**From:** Contact Centre (CRM) [REDACTED]  
**Sent:** 25 March 2024 17:12  
**To:** Planning  
**Subject:** Planning Application Comments - 3/2024/0134 FS-Case-599499028

**Planning Application Reference No.:** 3/2024/0134

**Address of Development:** The Black Bull,  
Old Langho Road  
Old Langho  
BB6 8AW

Re Application to form car park in adjacent field. The Black Bull, Old Langho, BB6 8AW Ref - 3/2014/0134

SHEET: PROPOSED SITE PLAN

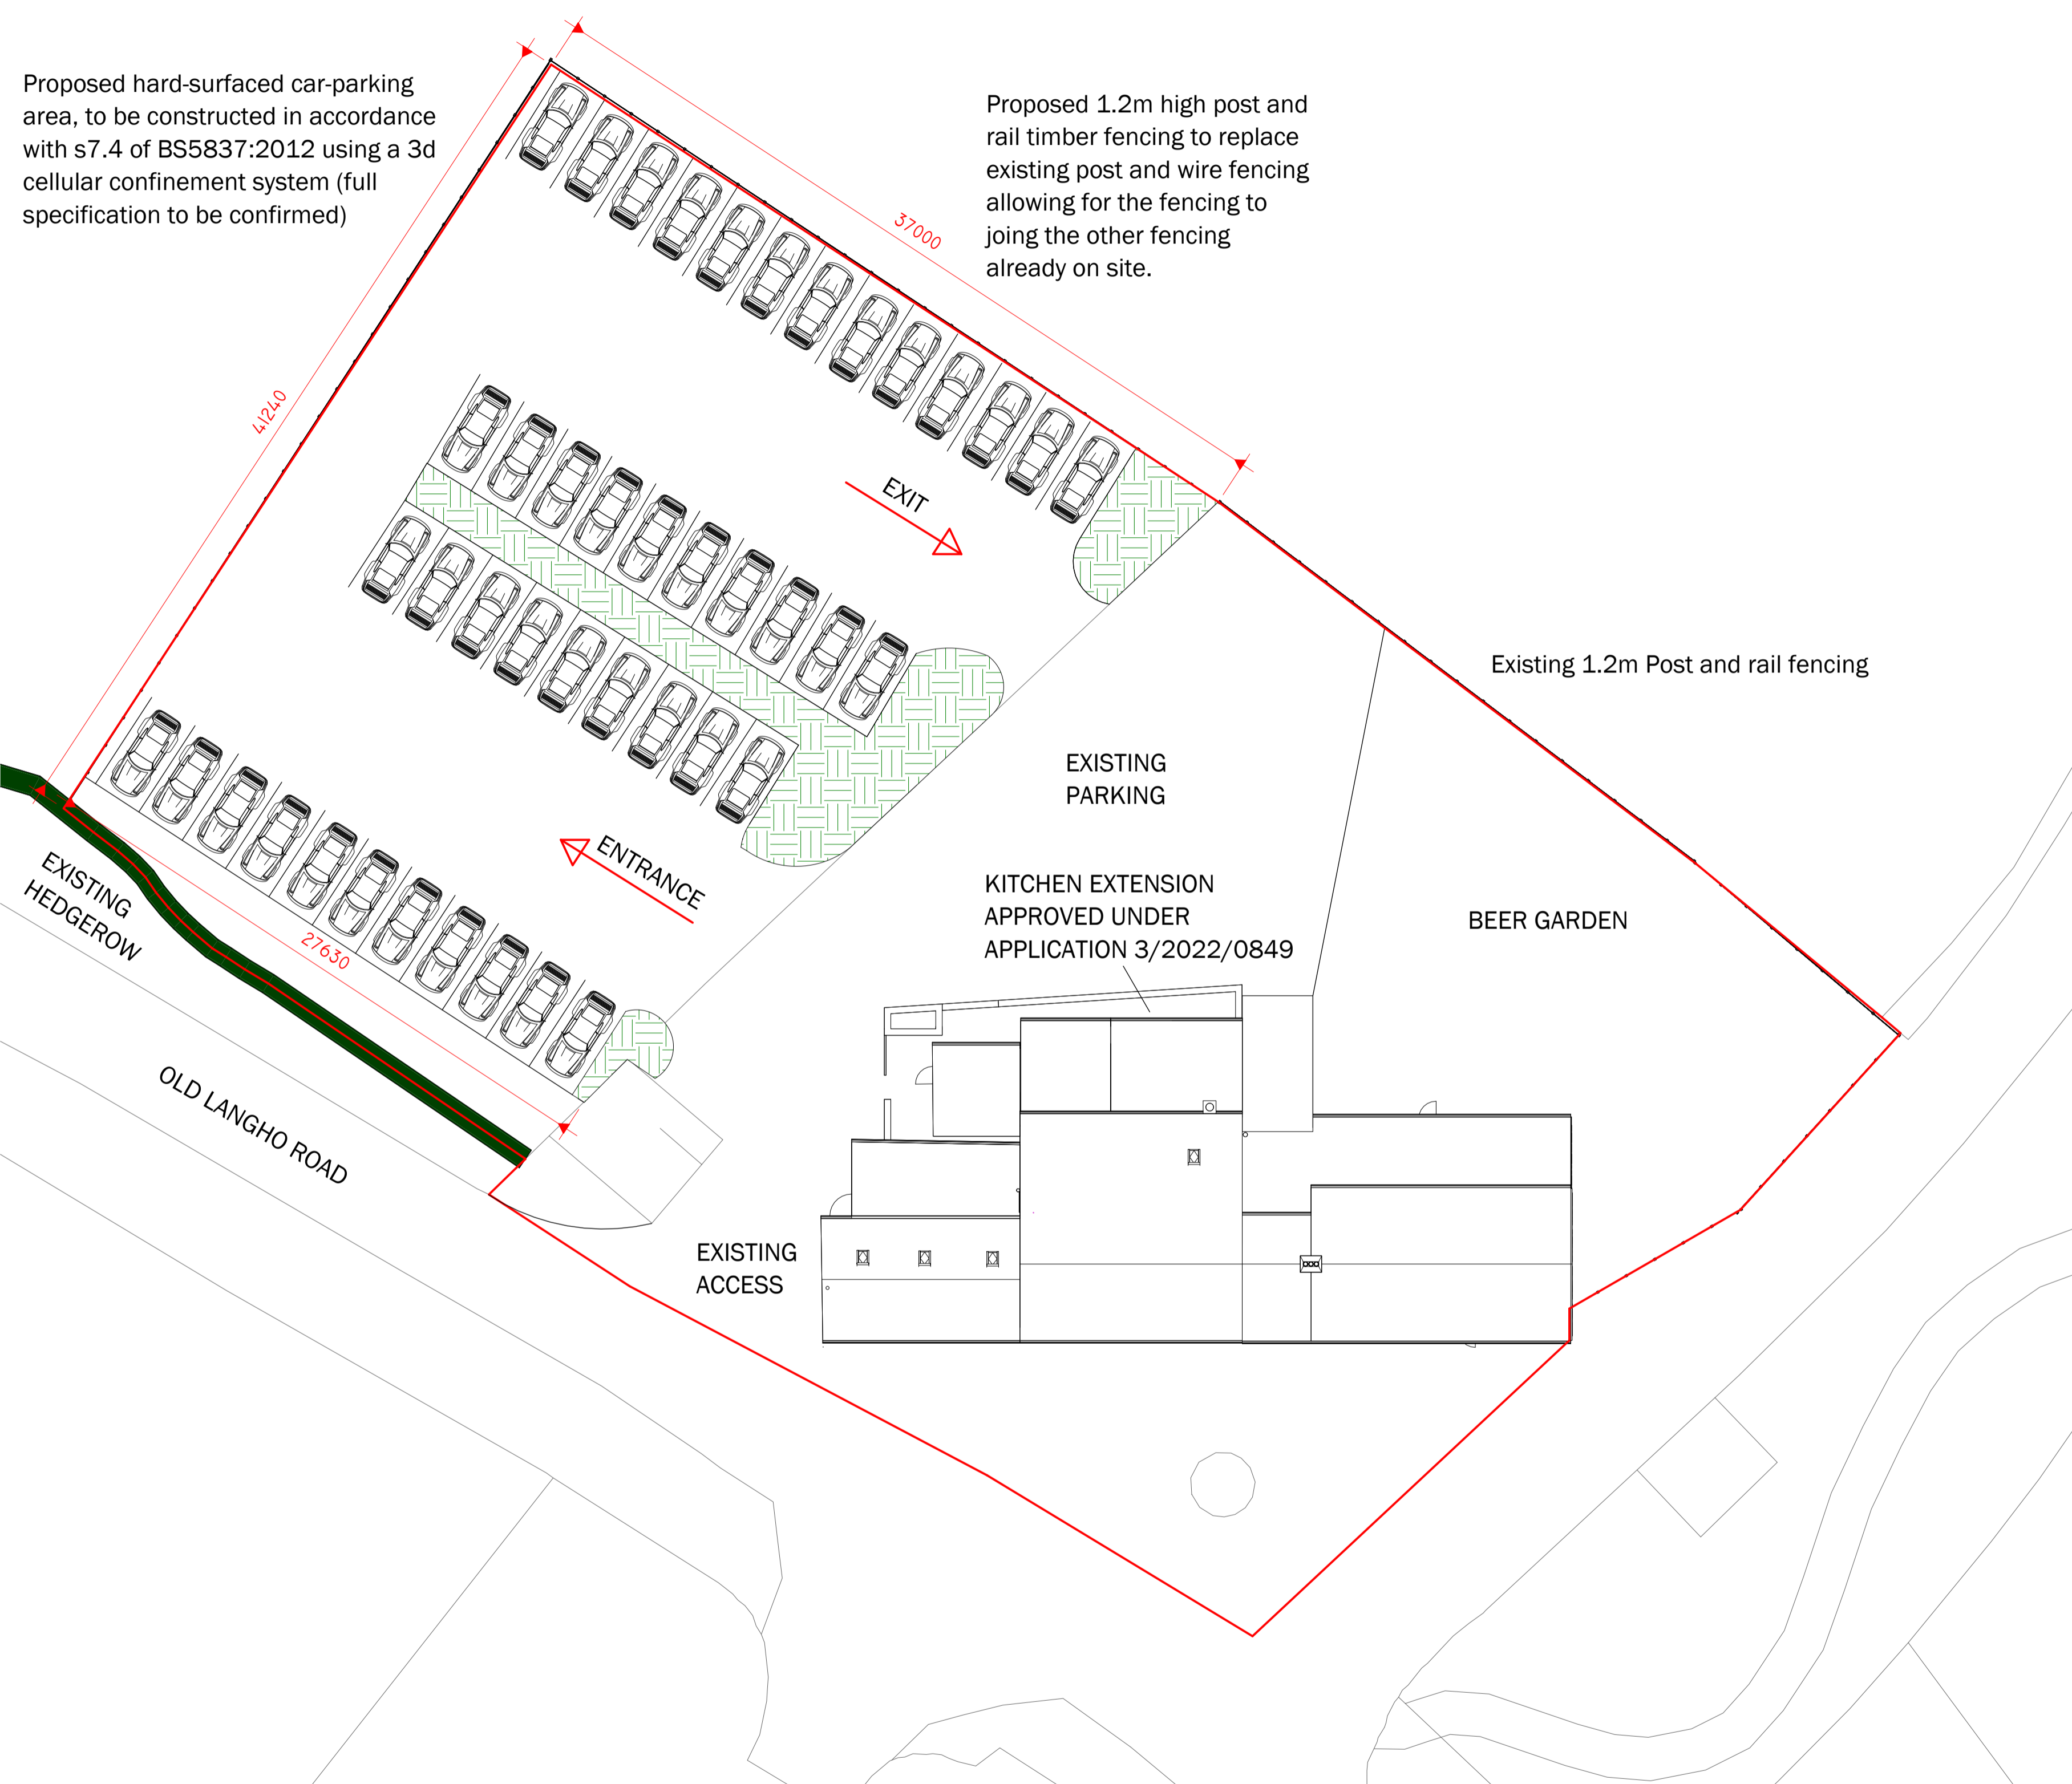
First, a suitable tree planting and landscaping scheme should be prepared to more effectively screen parked cars and their lights [REDACTED] but also to soften the impact of the car park on the surrounding countryside (the present application site plan has only very basic – and inadequate – detail). No details of Biodiversity Net Gain are provided with the application – as required by newly introduced legislation - but I assume that the Council will consider that aspect of the proposal and seek appropriate information which can then be suitably conditioned.

Secondly, (and also with impact upon the adjacent dwelling as well as the wider countryside in mind) any permission should consider car park lighting and be conditioned, as necessary, to avoid any floodlighting overspill, especially from high level units. We would like to suggest a condition which either prevents car park lighting or alternatively requires a scheme for low level lighting to be submitted for the Council's prior approval. Such a restriction would also safeguard local wildlife,
